Ref. 12853/APP/2023/1492
BY EMAIL

RESPONSE TO CONSULTATION FEEDBACK FOR PROPOSALS AT HAYES PARK CENTRAL AND SOUTH, HAYES PARK, HILLINGDON - PLANNING REF. 12853/APP/2023/1492

We write on behalf of our client, Shall Do Hayes Development Limited (the 'Applicant') in relation to the full planning application (Ref. 12853/APP/2023/1492) for the residential conversion of Hayes Park Central and South, Hayes Park, Hillingdon, UB4 8FE (the 'Site').

Canteen

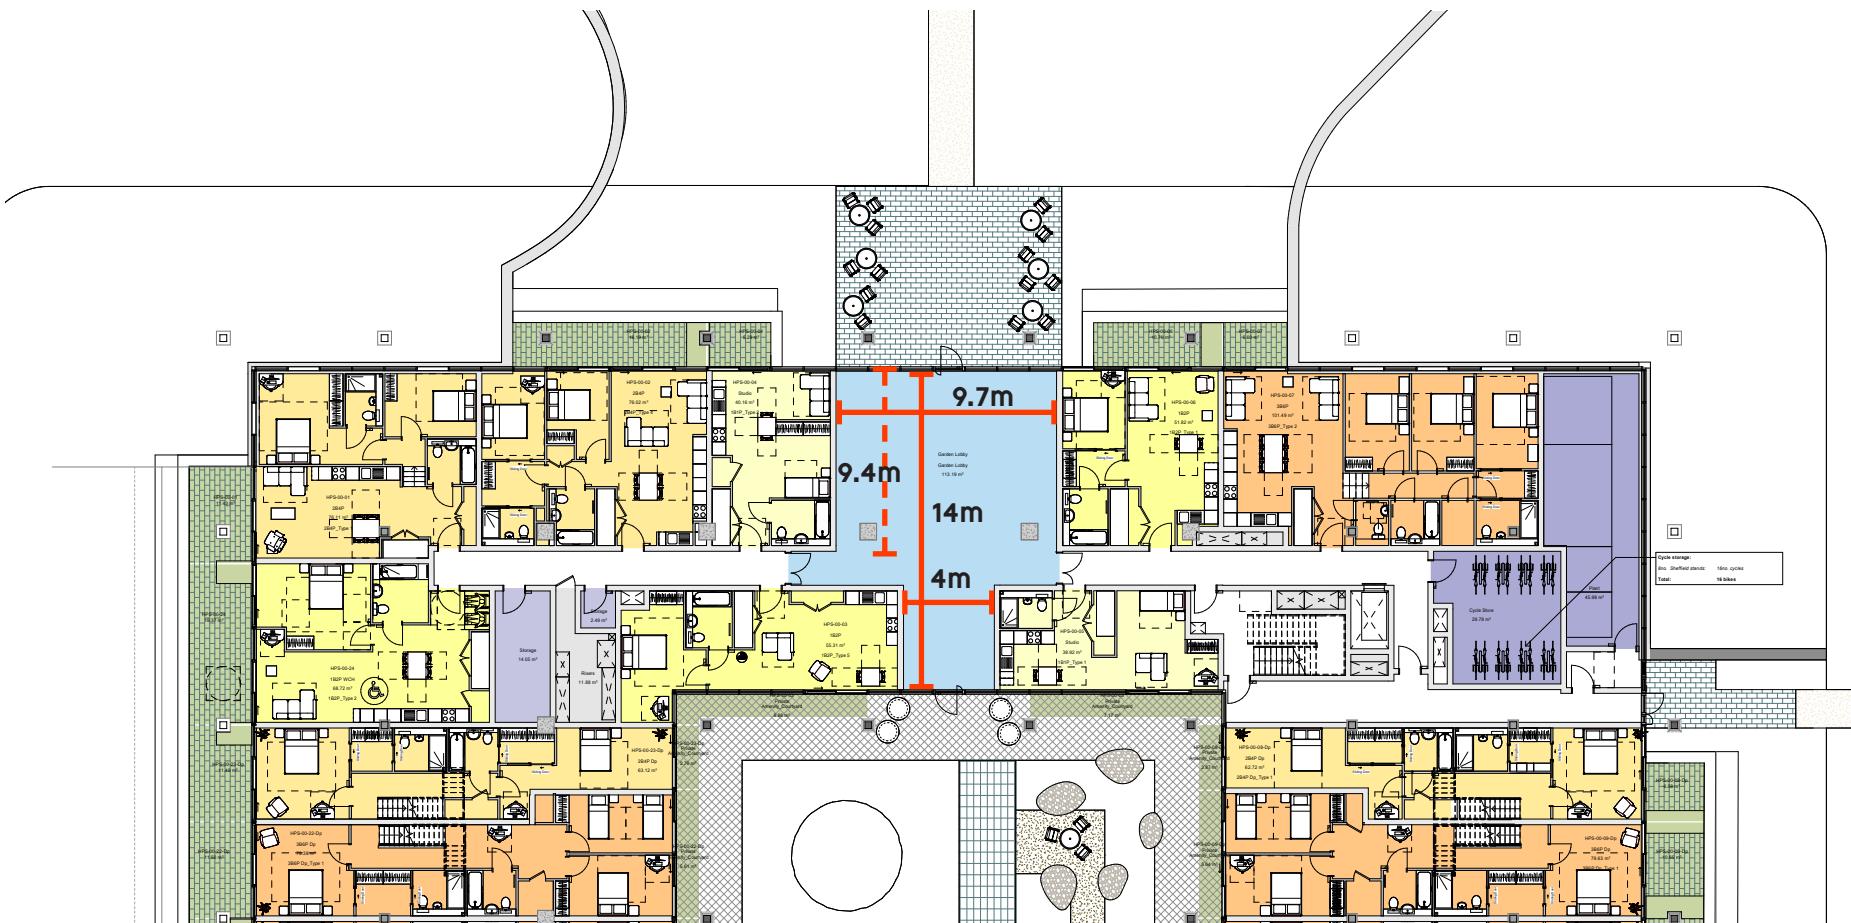
The LB Hillingdon Design and Conservation Officers noted some concern with the approach to the canteen. They stated that '*both from a heritage and liveability perspective, it would be preferable to increase the openness of the canteen as a communal social space*'. Their specific concern related to the sightlines through the building being limited to a narrower space than was originally there with the original canteen. As such, officers requested that the canteen area, or entrance into this area, be made larger to provide more amenity space and wider sightlines through the building.

SEW have prepared an architectural response to this in the accompanying design statement (page 27). In summary, the Applicant considers that the proposed space is wholly appropriate for the new use of the building and is not intending to amend the size of the canteen space for the following reasons:

- The new canteen space has been designed to function as an internal communal lobby space and its dimensions are appropriate for this quantum of residential use.

- The sightlines through the building have been retained. A 4m wide route into the central courtyard from the canteen space is proposed. This is considered to be a generous size and again wholly appropriate for the proposed residential use. The previous canteen space needed to be very large to accommodate the large number of staff that would have used it a defined time.

- Retaining the symmetry of the canteen space is important for the heritage of the building. The partitions of the canteen space have been designed to align with the existing curtain wall locations. If the canteen entrance were to be widened, to retain this symmetry it would need to be widened by an additional two bays, totalling 2.8m.

- The resulting space would feel oversized for its function. The residents have access to a significant quantum of amenity space as part of this scheme, through the wider landscaping and courtyards. It is not considered necessary to make this internal space any larger.

- Increasing the width would result in the adjacent homes falling below space standards. So essentially resulting in the loss of two homes and therefore impacting on the viability of the proposed development

Accommodation Quality Reflective Pool

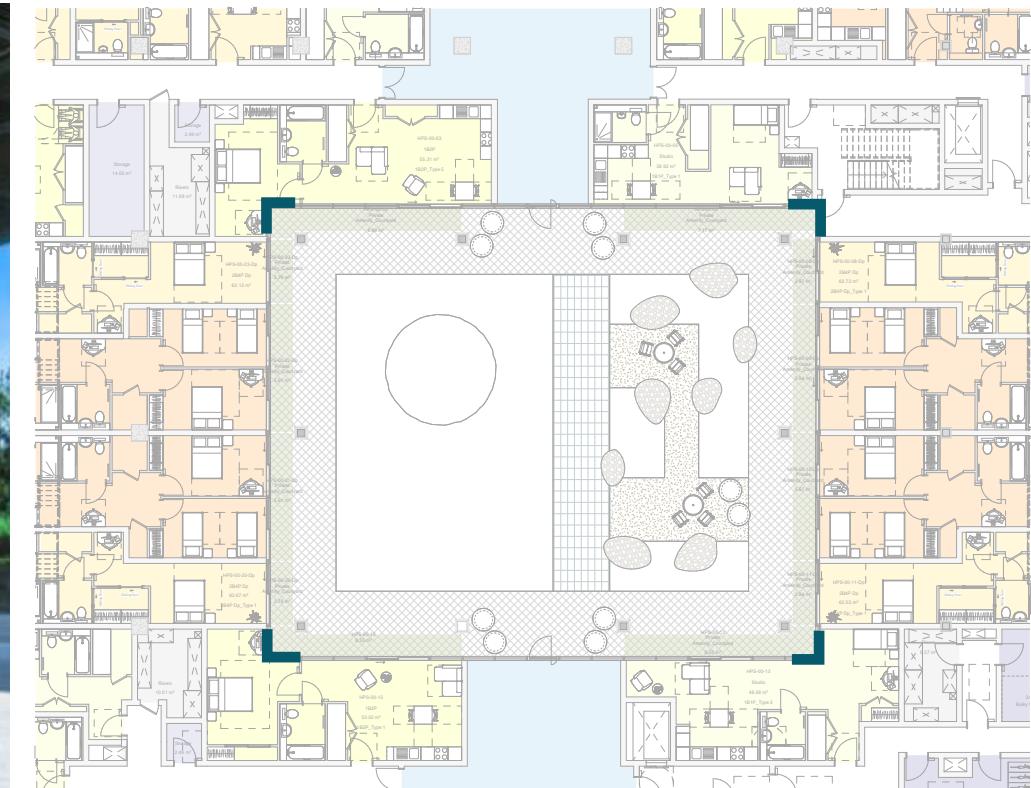
The HPS internal courtyard has been reconfigured to create a usable communal space. LB Hillingdon Design and Conservation officer noted that encouraging the use of the courtyard as communal amenity has the potential to create privacy and noise issues.

The Applicant is keen for residents to have access to as many different amenity spaces as possible. Residents will have access to the grounds surrounding the site, their own private balconies, as well as these central courtyards. The courtyards are designed to be quite spill out spaces, and they have been designed to encourage residents to meet and socialise. There are many examples where these types of spaces have been successful in encouraging community cohesion within new residential developments (see examples in SEW Design Response page 29).

Nevertheless, SEW have shown how planters could be introduced to provide additional screening and defensible space, which would help to increase the privacy available to residents living at the ground level. This change has been shown on drawing 0419-SEW-HS-00-DR-A-253225.

Hayes Park Central and South

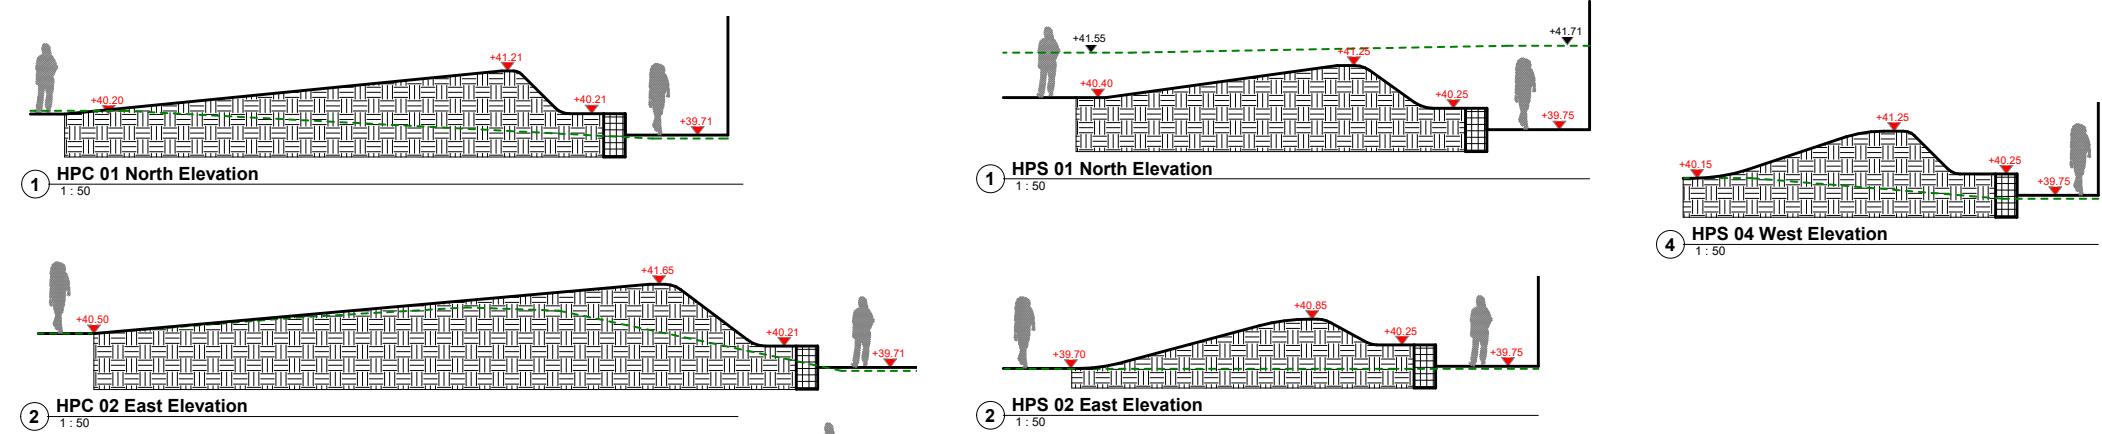
Clarification was sought from both LB Hillingdon and Historic England on the extent of the cut outs. SEW have prepared two new drawings demonstrating the location and depth of the cut outs (0419-SEW-ZZ-00-DR-L-001005 and 0419-SEW-ZZ-00-DR-L-001006) and further details are provided on page 32 of the Design Response document.

In order to provide more private external amenity space for the homes, as well as improved daylight and sunlight, SEW have introduced some landscape cut outs in the ground surrounding the buildings. These cut outs also have the benefit of creating a landscape mound surrounding the buildings, which means the buildings appear as two-storey structures. Appearing as a two-storey structure was an important element of the original proposals due to their location within the Green Belt.
